**Section 96A of the Town & Country Planning Act 1990 (as amended)
Town and Country Planning (Development Management Procedure) (England) Order 2015
(as amended) - Article 10**

Non-material amendment following grant of A/219/17/PL to:-

Land East of Mayflower Way Windy Ridge Angmering BN16 4AY

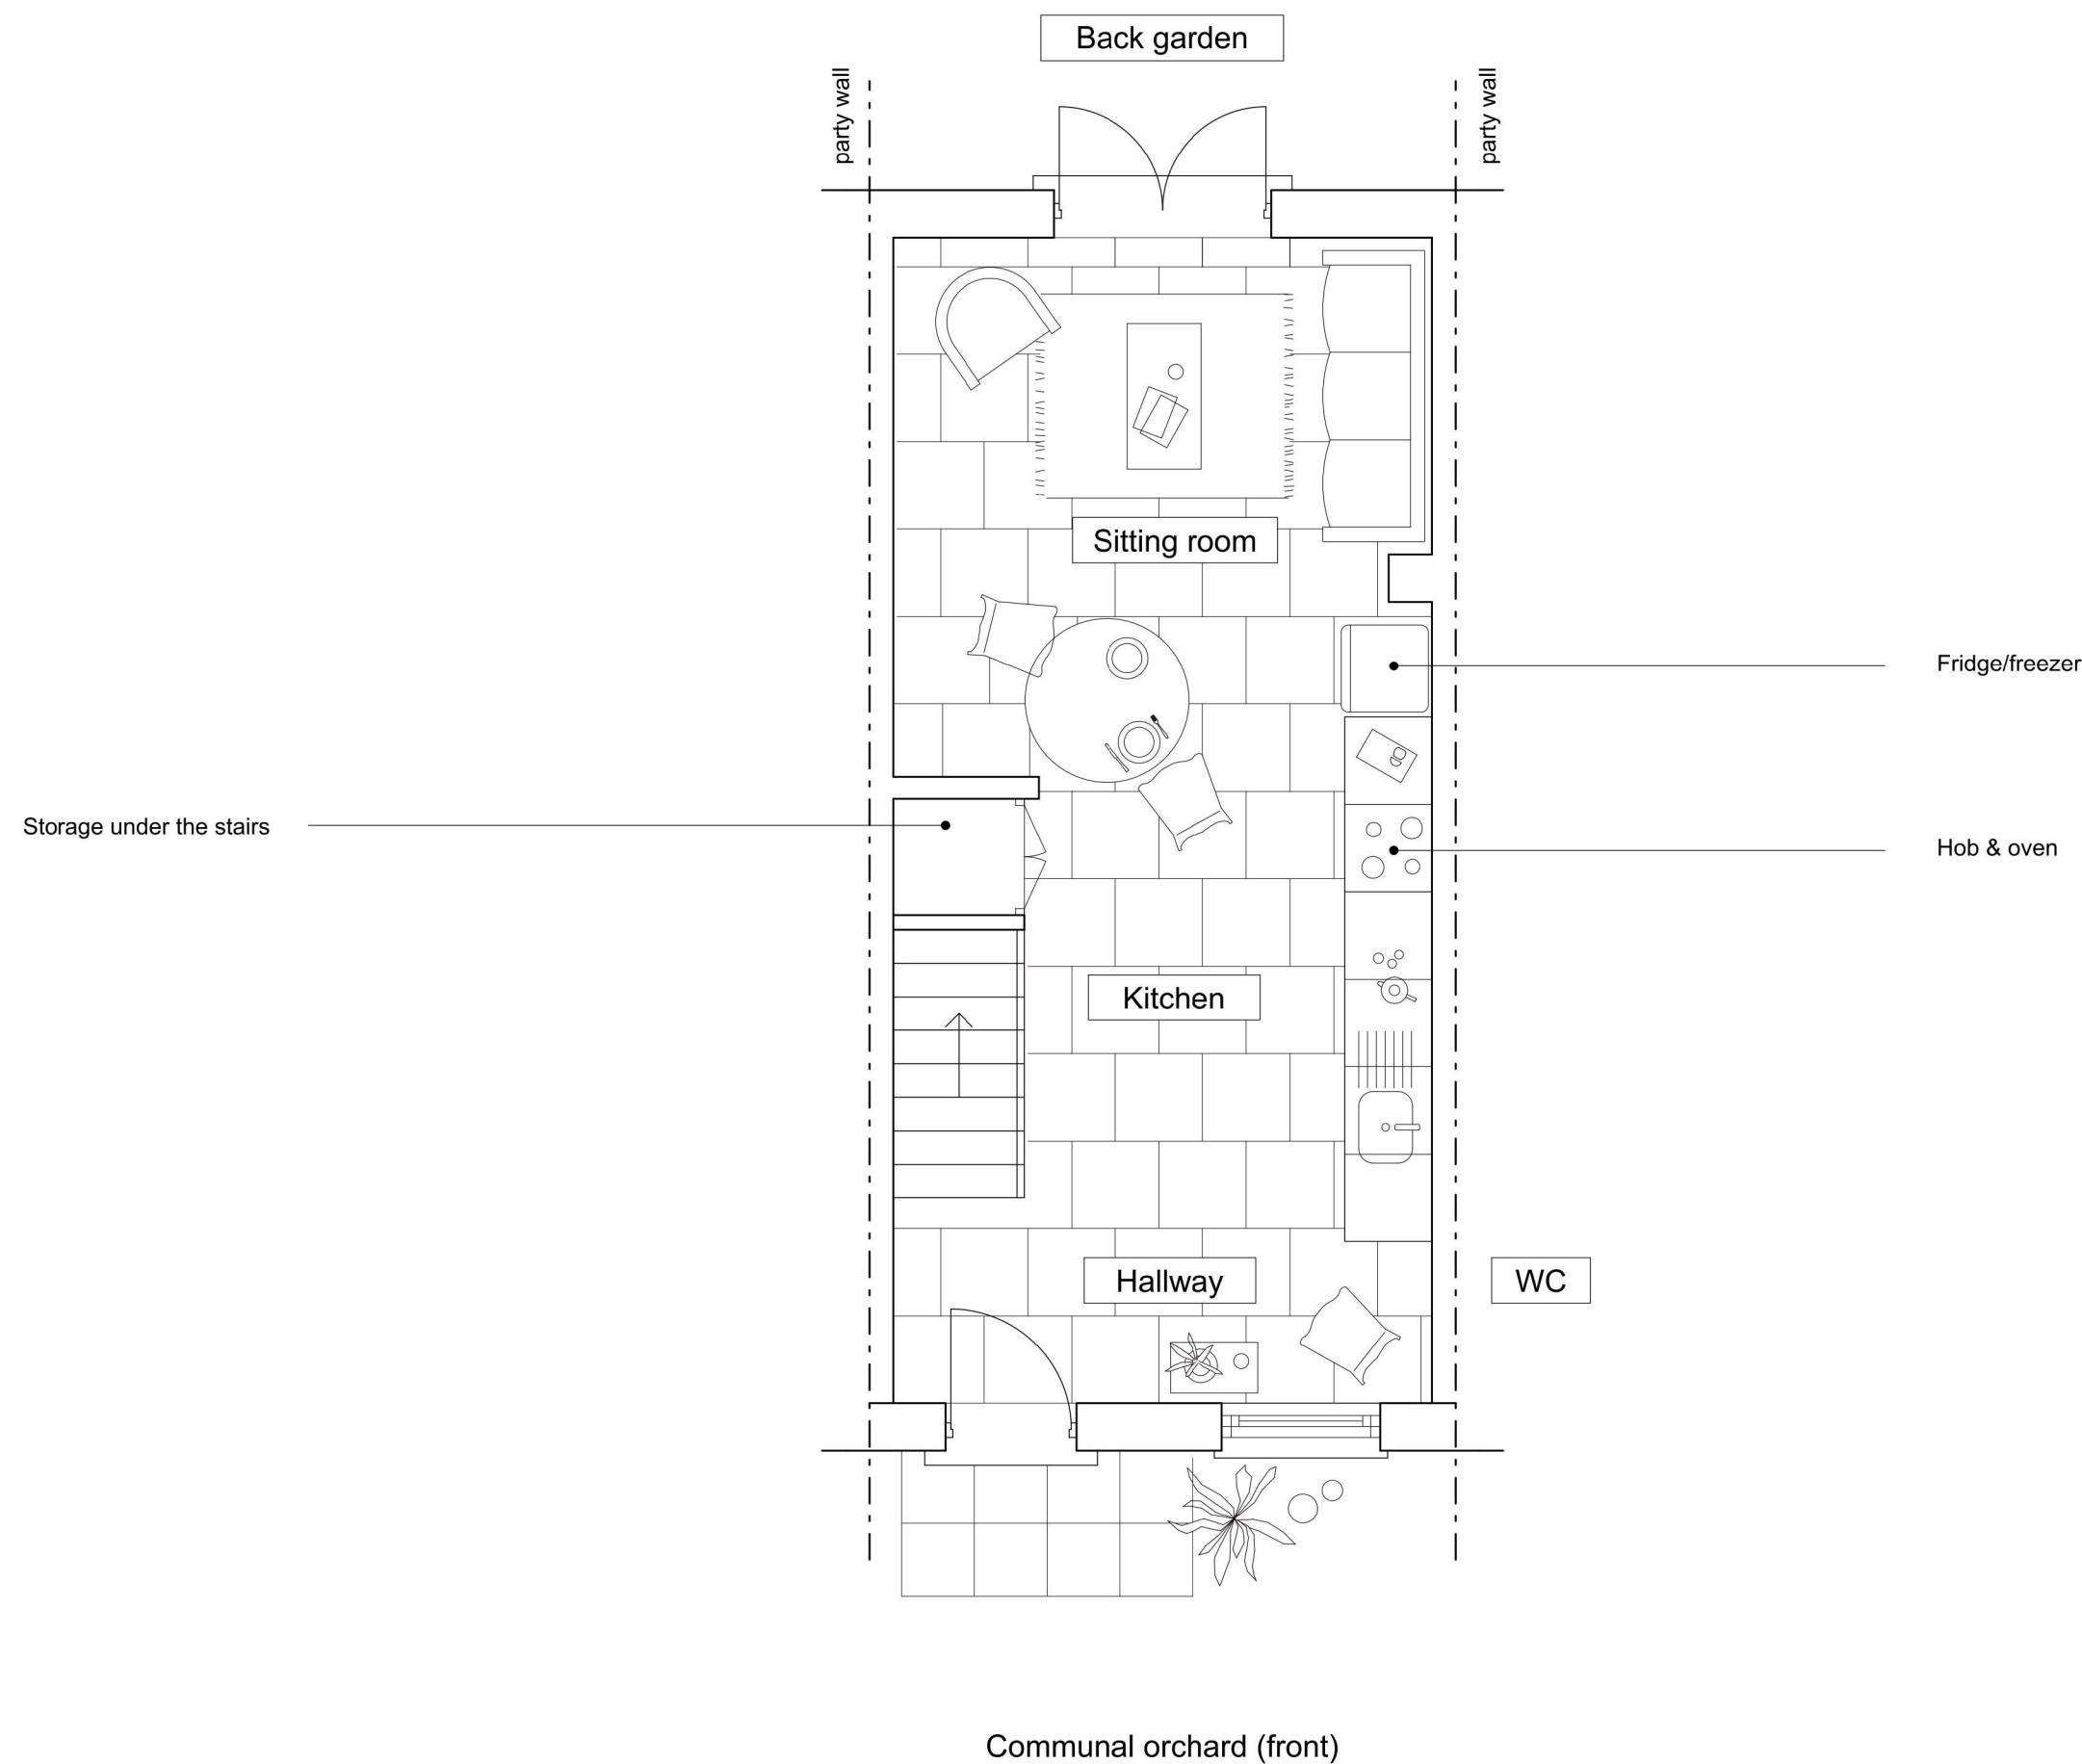
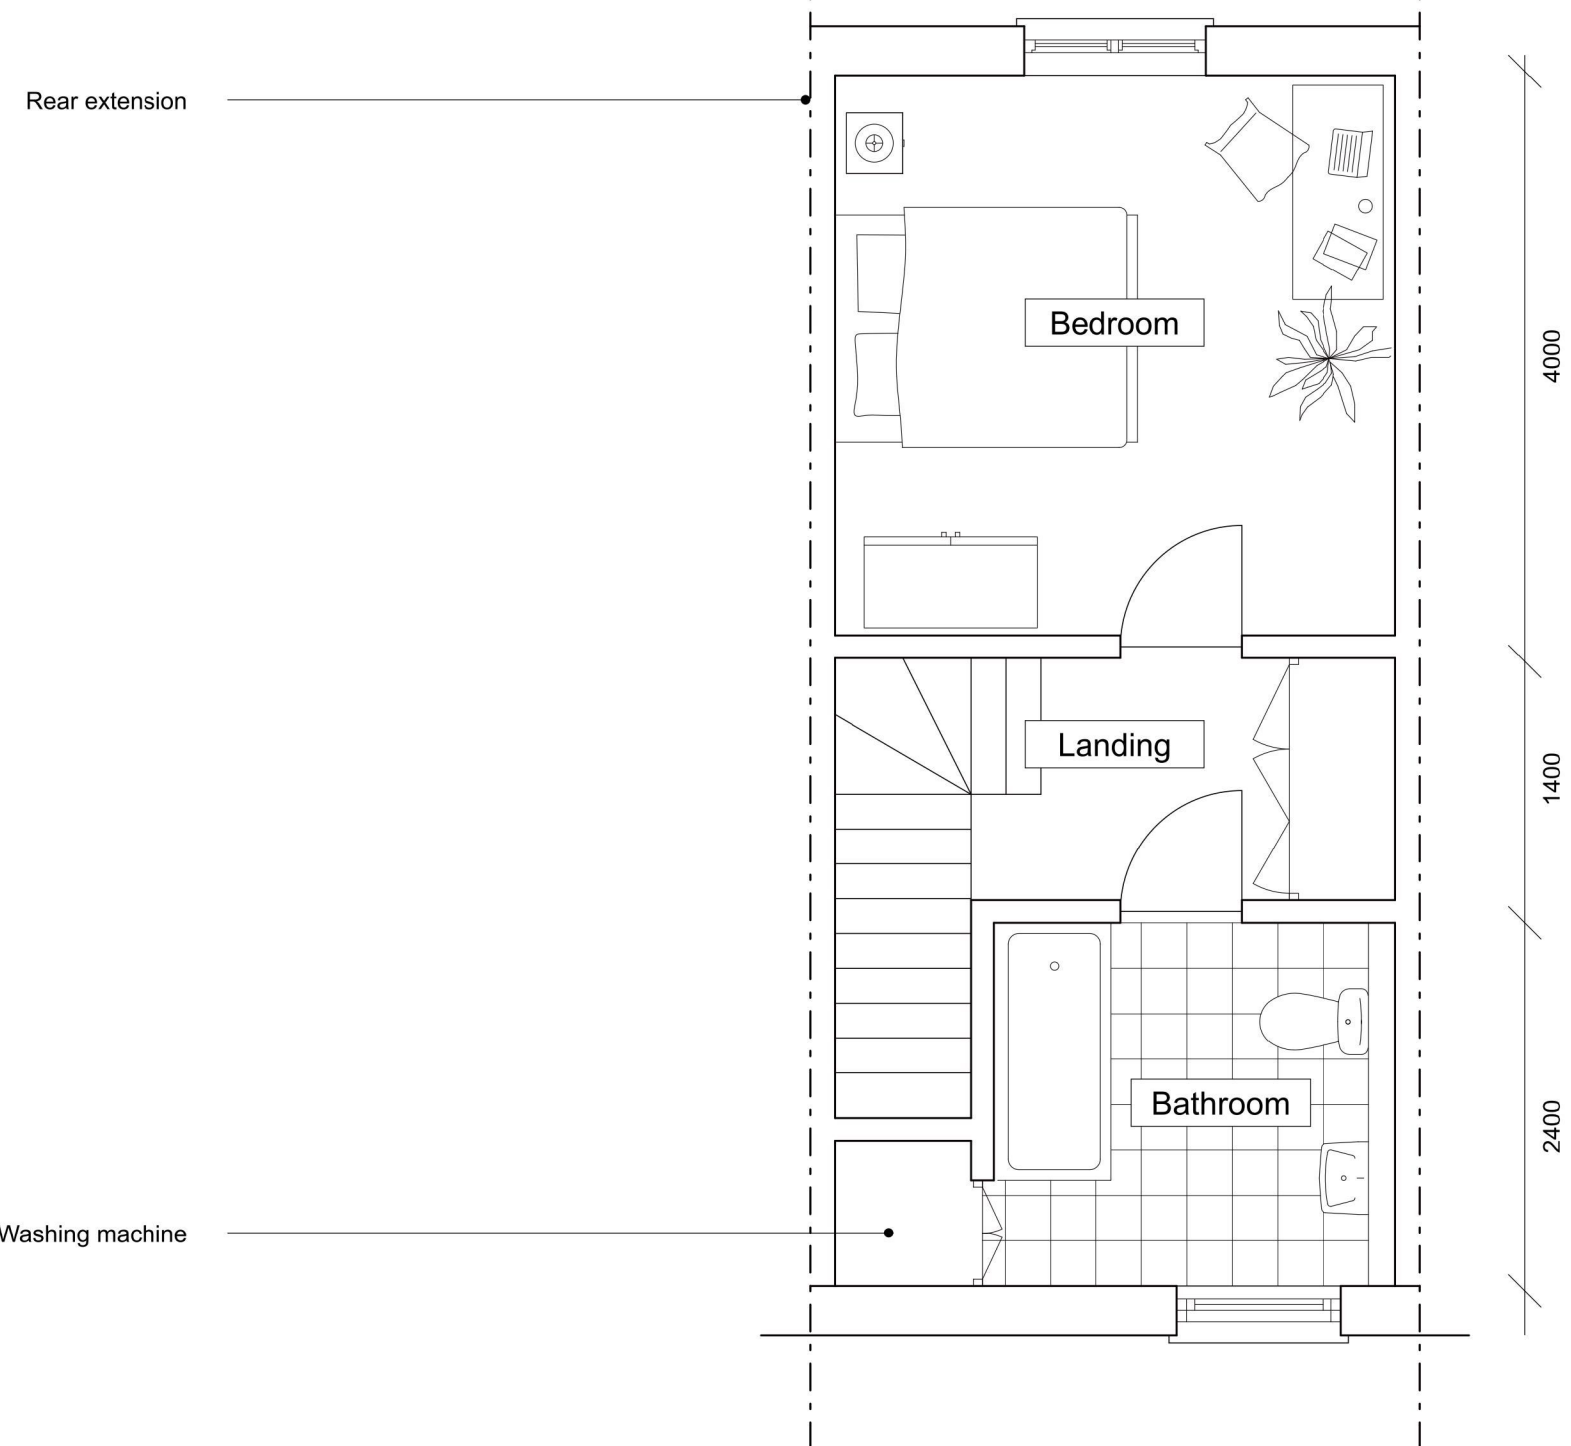
1 - to remove the galvanised steel flues however all chimneys will remain but non-functional, with traditional masonry flues (pots), 2 - roof tiles shown as clay pantiles will be changed to concrete pantiles while providing the same overall appearance, 3 - roof tiles to be artificial Slate providing the same overall appearance, 4 - rainwater goods to be black PVCu with cast Iron effect, 5 - windows to be PVCu white providing the same overall appearance, 6 - front doors to be GRP composite PAS24 while providing the same overall appearance, 7 - Lintol treatment amended where noted on drawings: RSJ detail changed in favour of homogenous brickwork, & window lintol treatment amended as noted,

17.319-P01 Rev A Terrace A Floor Plans and Elevations
17.319-P02 Rev A Terrace B Floor Plans and Elevations
17.319-P03 Rev A Terrace C Floor Plans and Elevations
17.319-P04 Rev A Terrace B 2 Bed Detail Floor Plans and Elevations
17.319-P05 Rev A Terrace B 3 Bed Detail Floor Plans and Elevations
17.319-P06 Rev A Terrace A 1 Bed Detail Floor Plans and Elevations
17.319-P07 Rev A Terrace C Flats Detail Floor Plans and Elevations
